Application No: EP/71/26/HH
Site Address: 51 Warren Crescent East Preston BN16 1BL
Description of works: Extension to the side and infill extension to the rear, new roof and loft conversion and alterations to fenestration including removal of front porch.

Thank you for your internet representation made on 25th August 2026 which has been recorded as an objection with the comments as follows:

This council's Planning & Licensing Committee considered this application at its meeting on Monday, 24th August.

Project	ARCH2026_WaCI-R	Sheet
Date	30.06.2026	A104-C
Scale	as stated	
PLANNING ISSUE

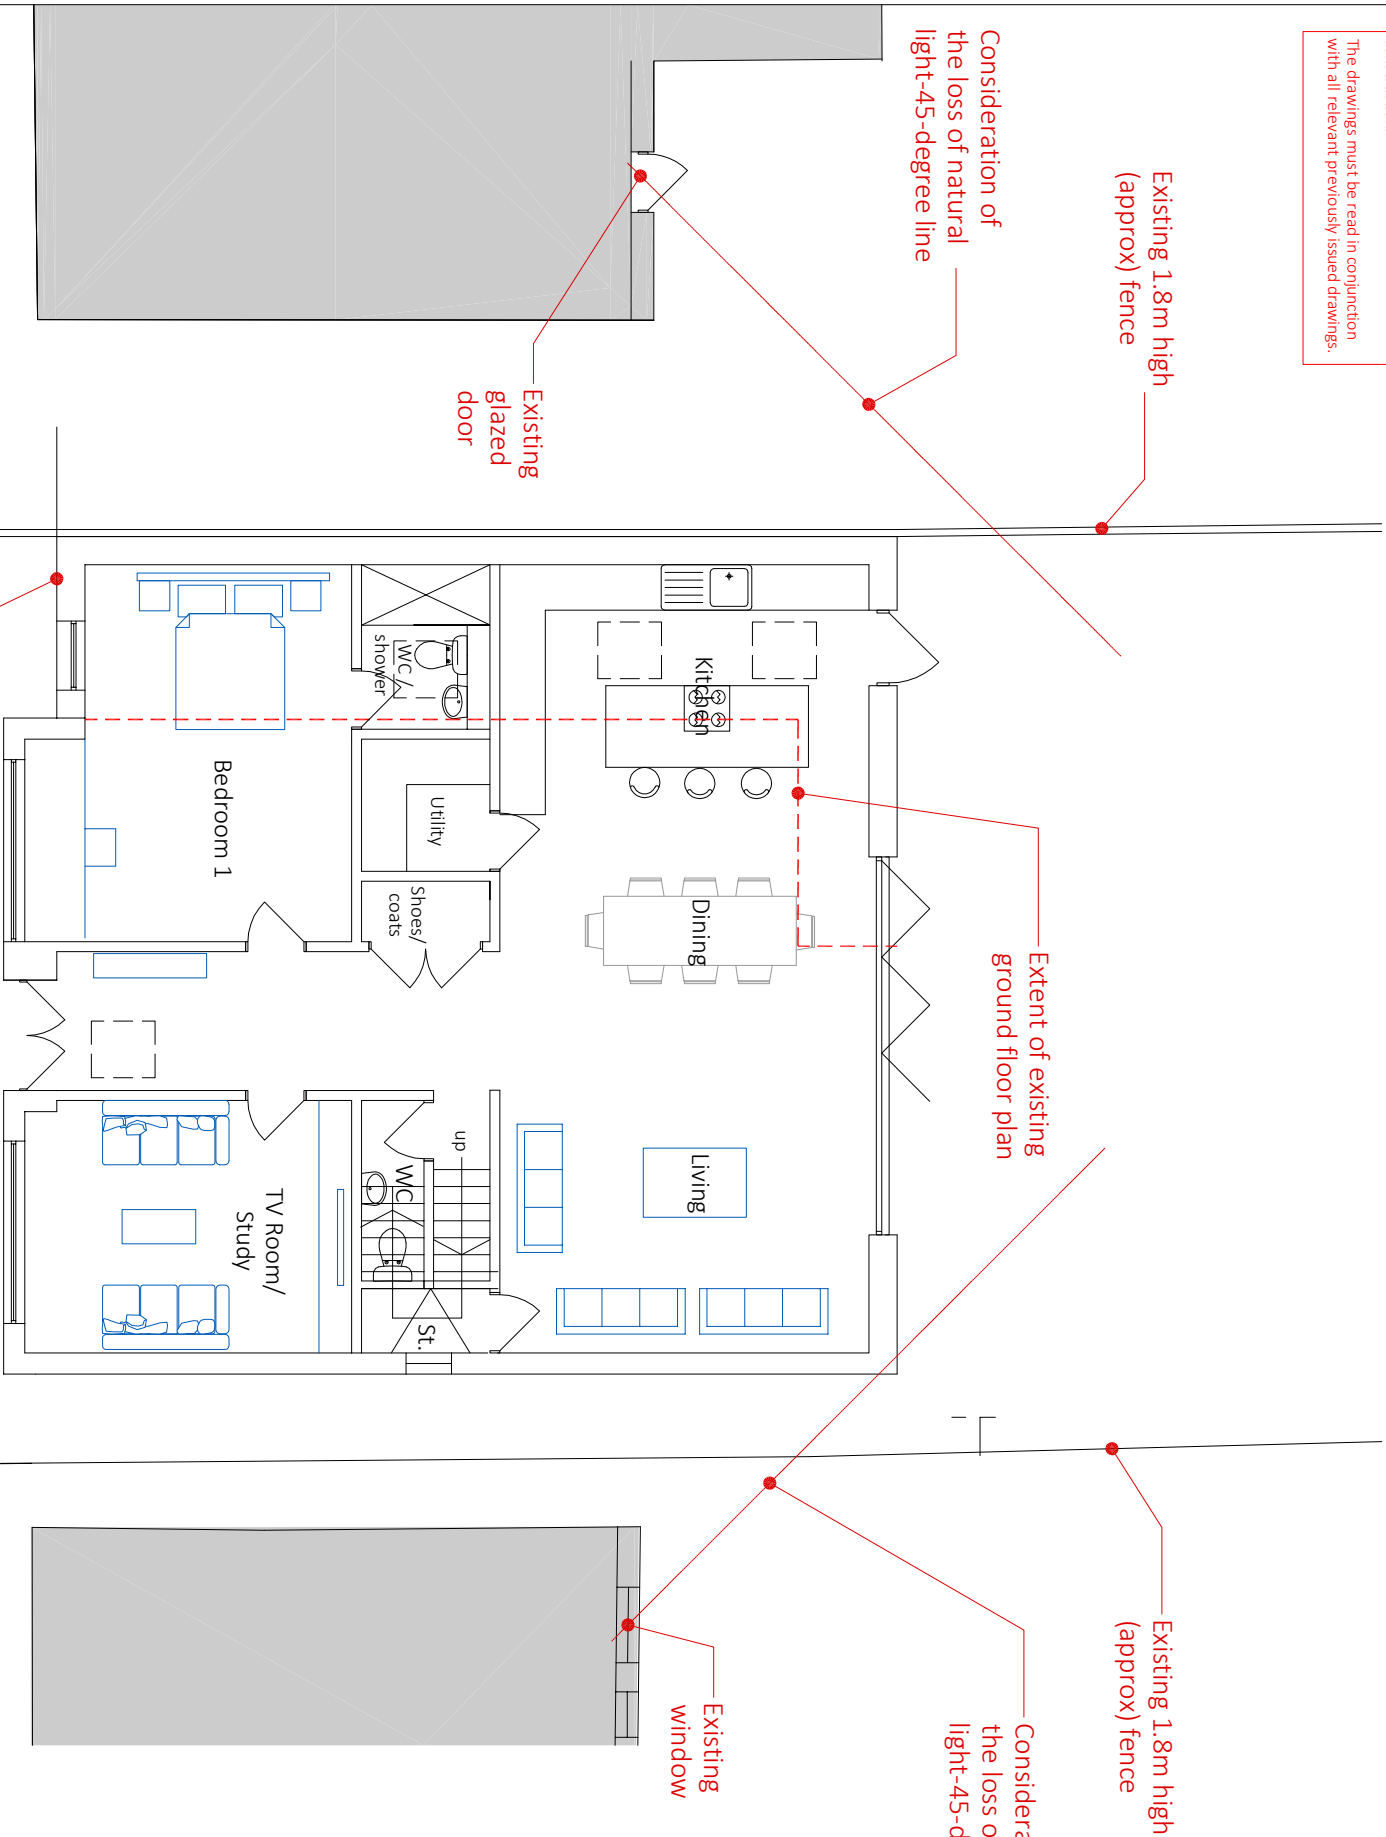
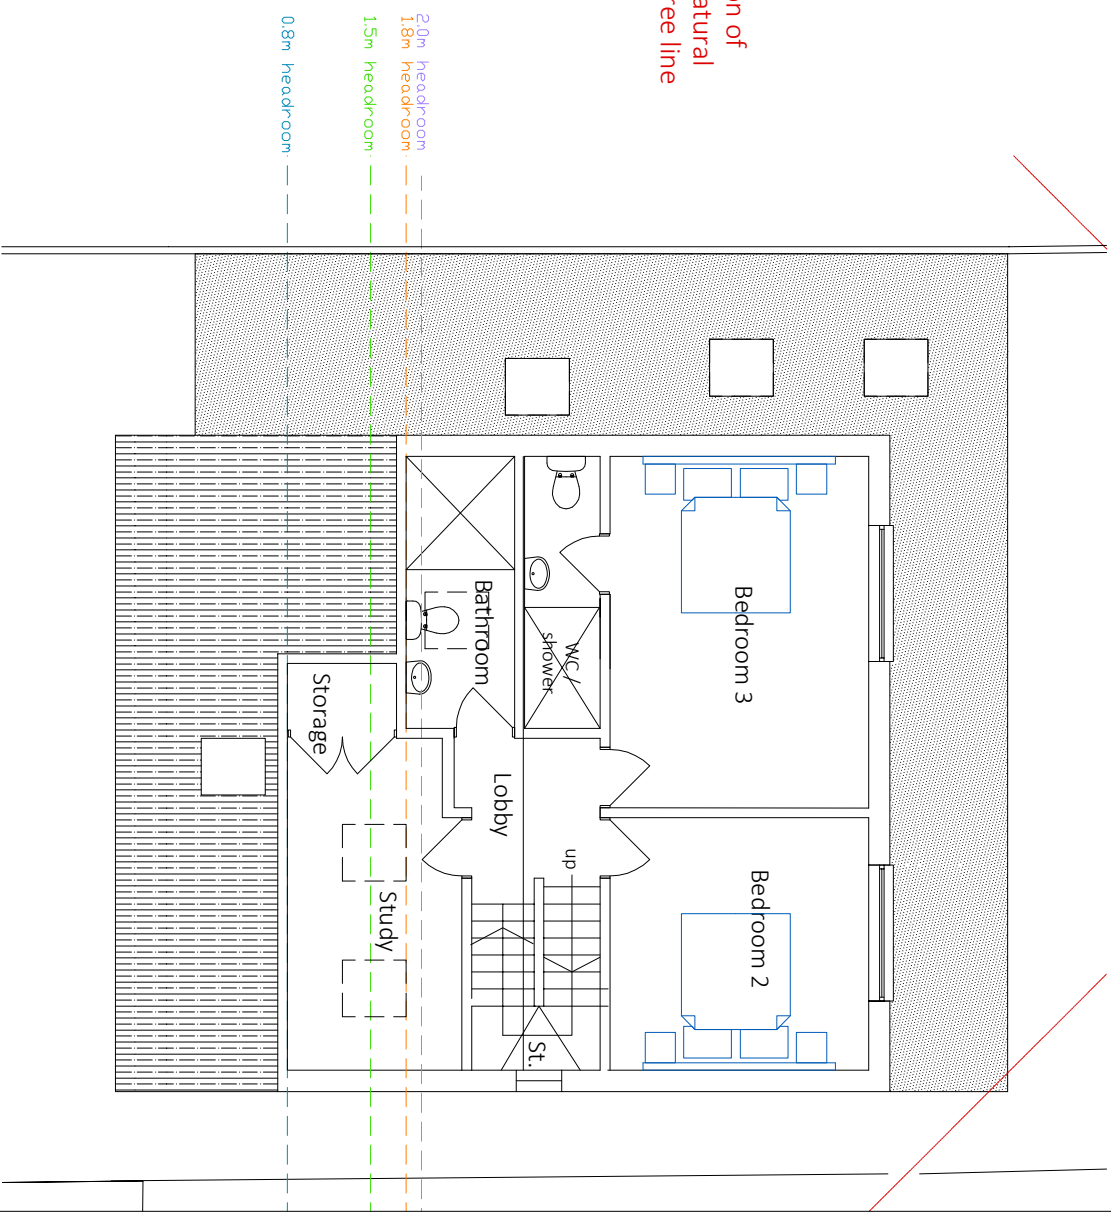
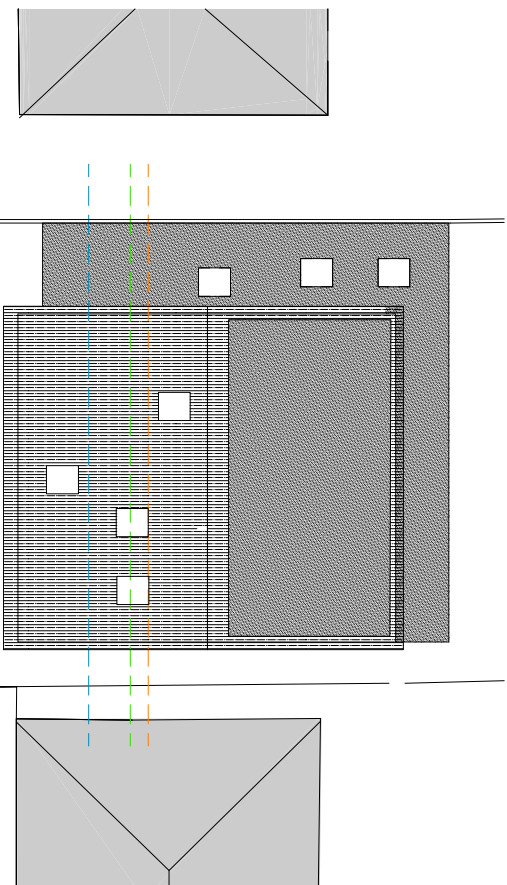
The proposed development will be right up against the boundary with no. 49, and the committee felt this would be overbearing to the neighbouring property.

Project	ARCH2026_WaCI-R	Sheet
Date	30.06.2026	A105-C
Scale	as stated	
PLANNING ISSUE

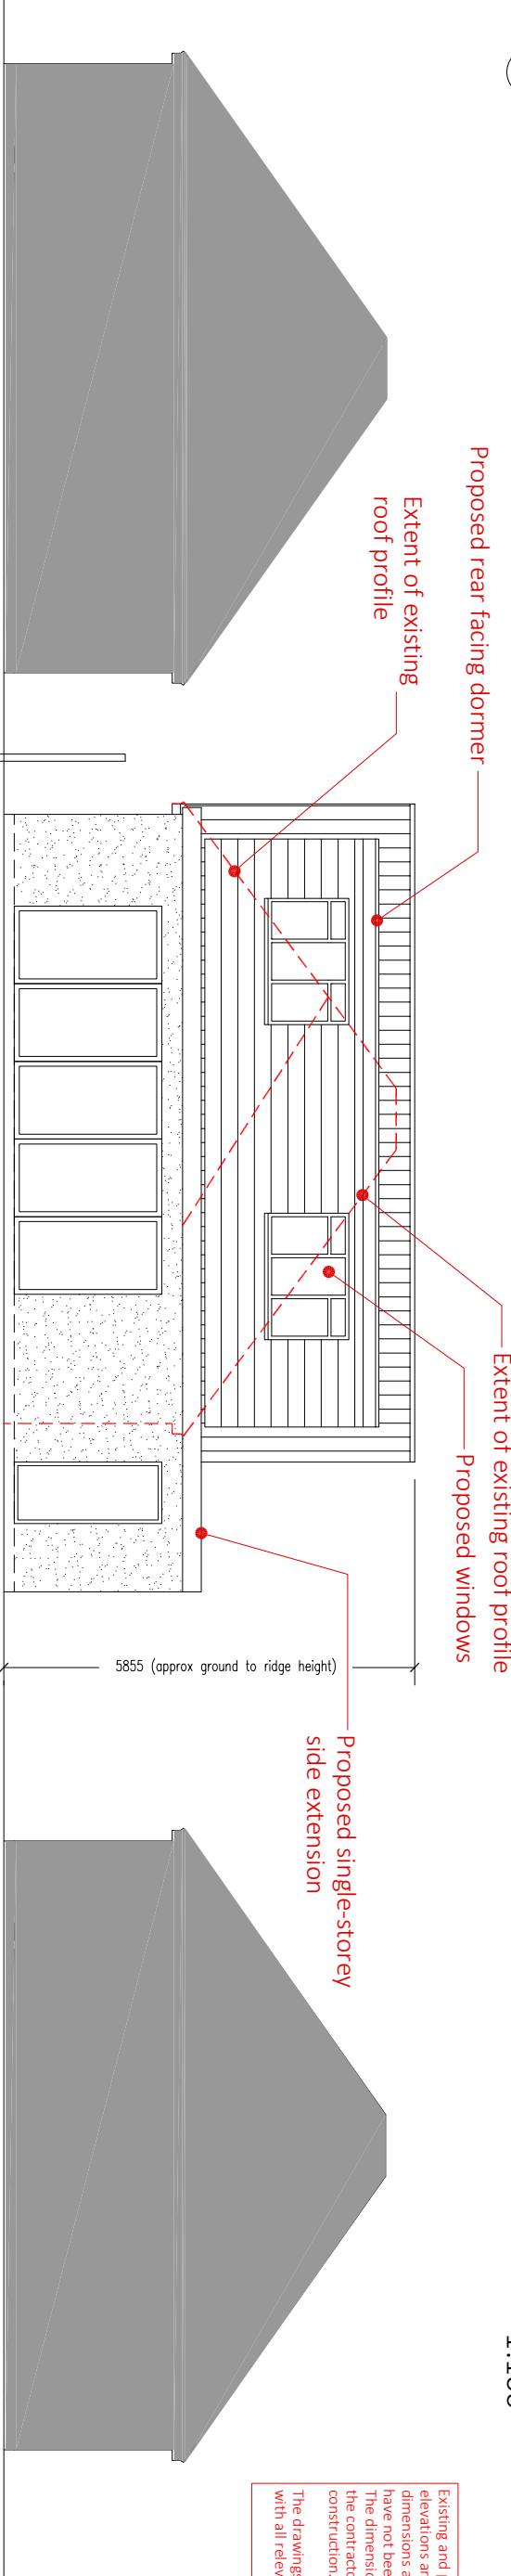
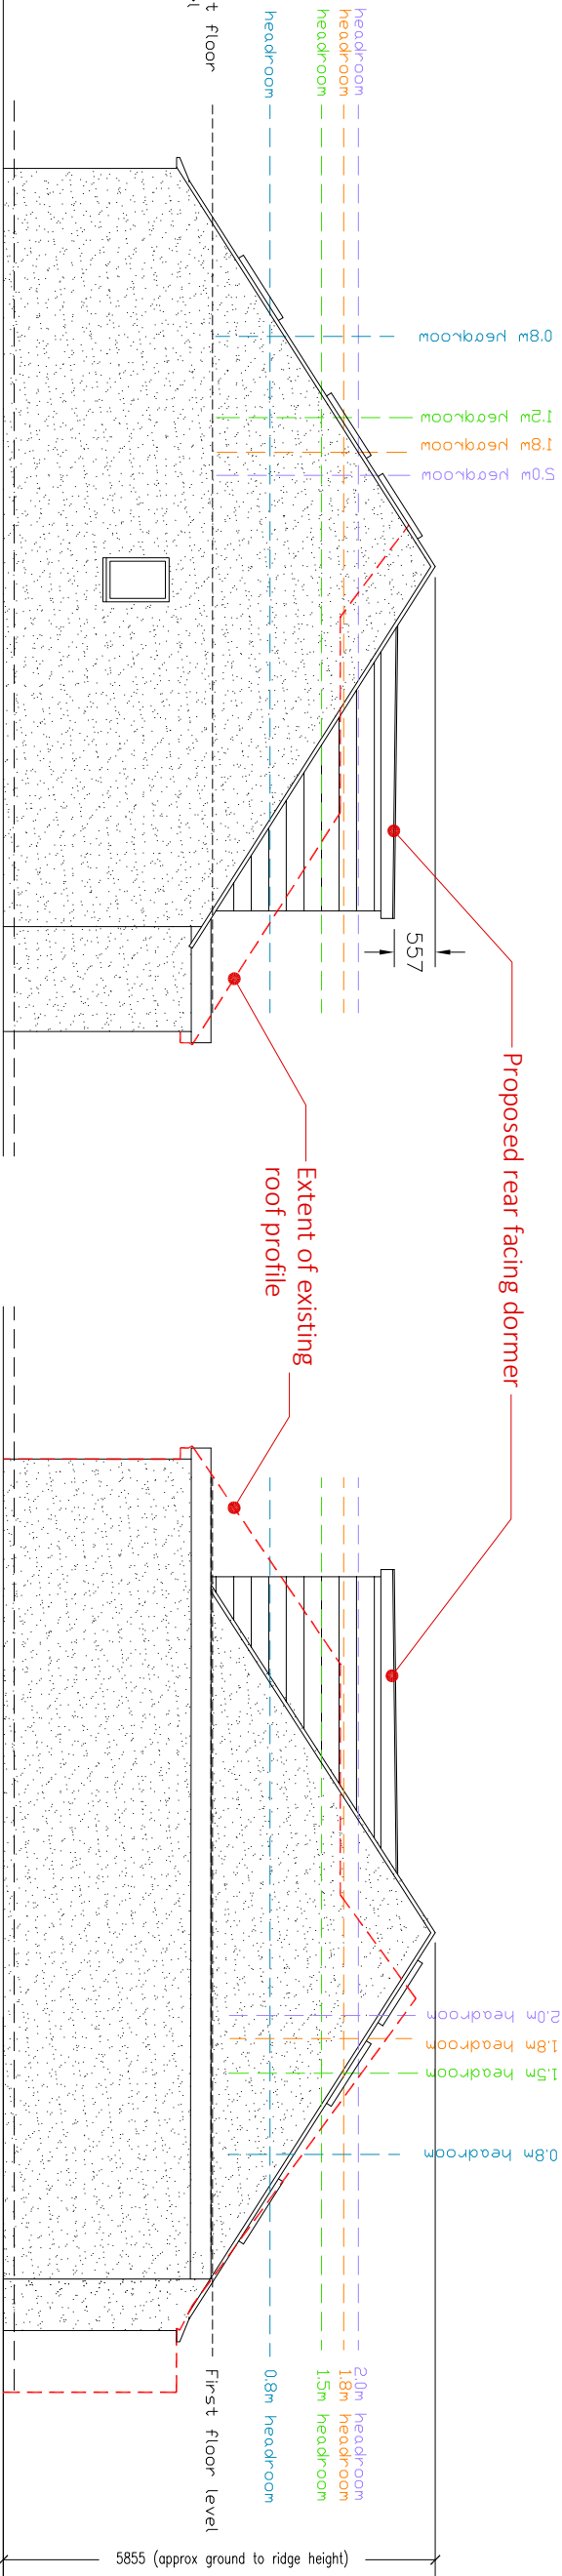
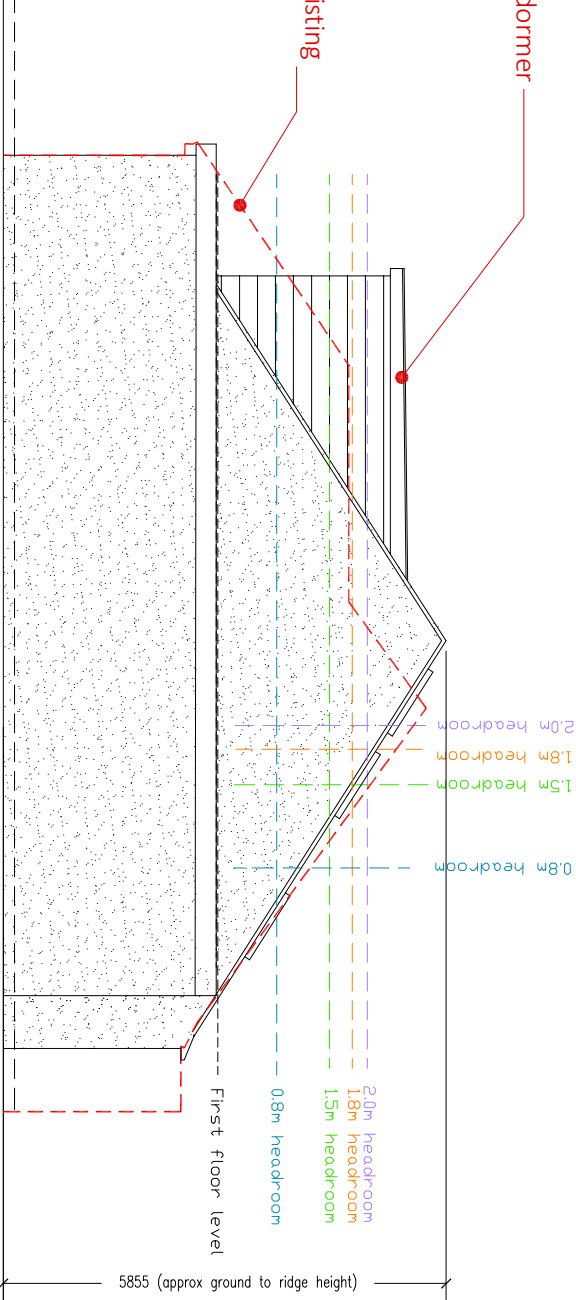
The proposed design would not be in keeping with the streetscene, being visually too square. This would be contrary to Policy 1 of the East Preston Neighbourhood Plan which states buildings should "reflect and enhance the architectural and historic character" of the area.

The proposed roofline will make the property taller than its neighbours.
